12683 Fulfort Ct.

Please add "PCD
File No. AL-22-006"

Site Plan Drawing_v1.pdf Markup Summary

MAIN FLOOR PLAN

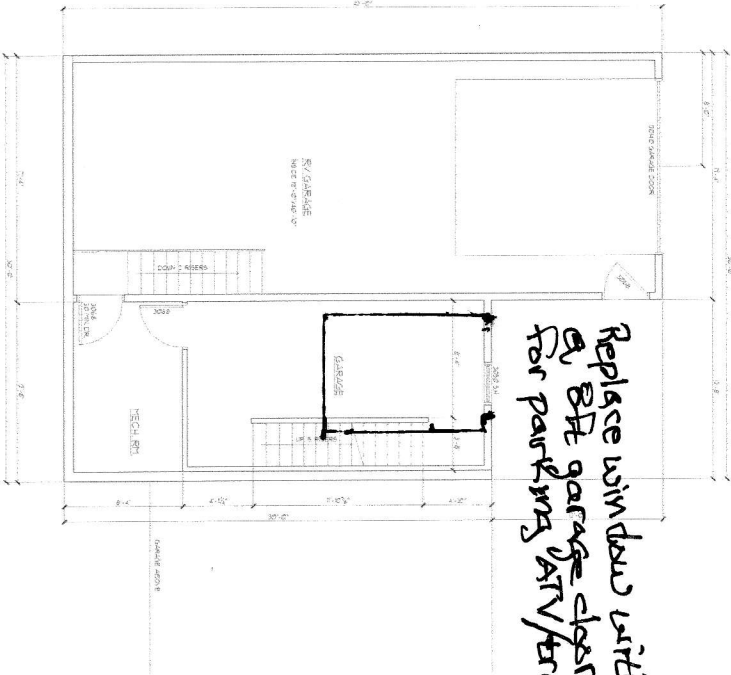
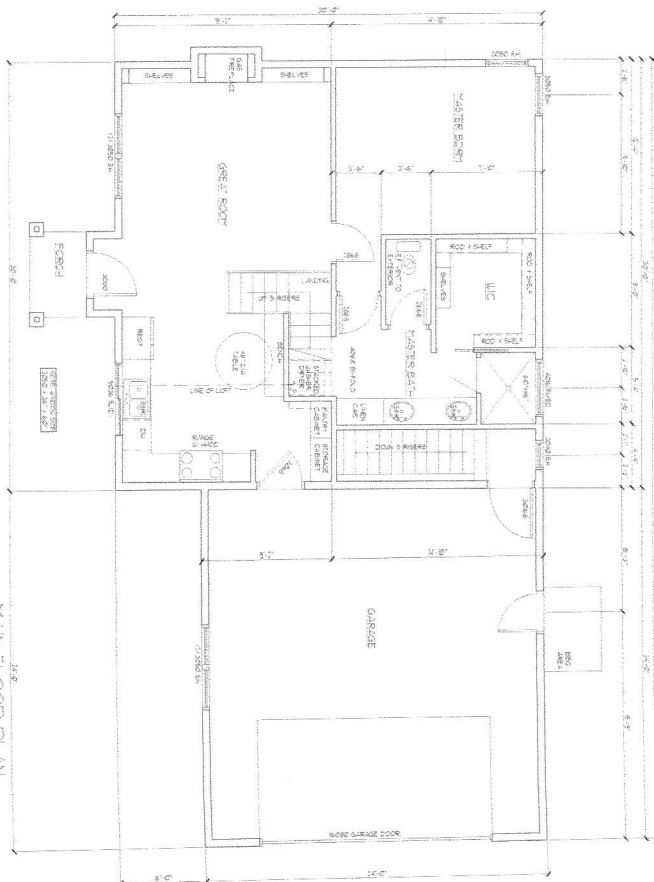
-Please provide a floor plan for accessory unit
-Please depict sq ft for inhabitable space and sq ft for inhabitable space (accessory structure)
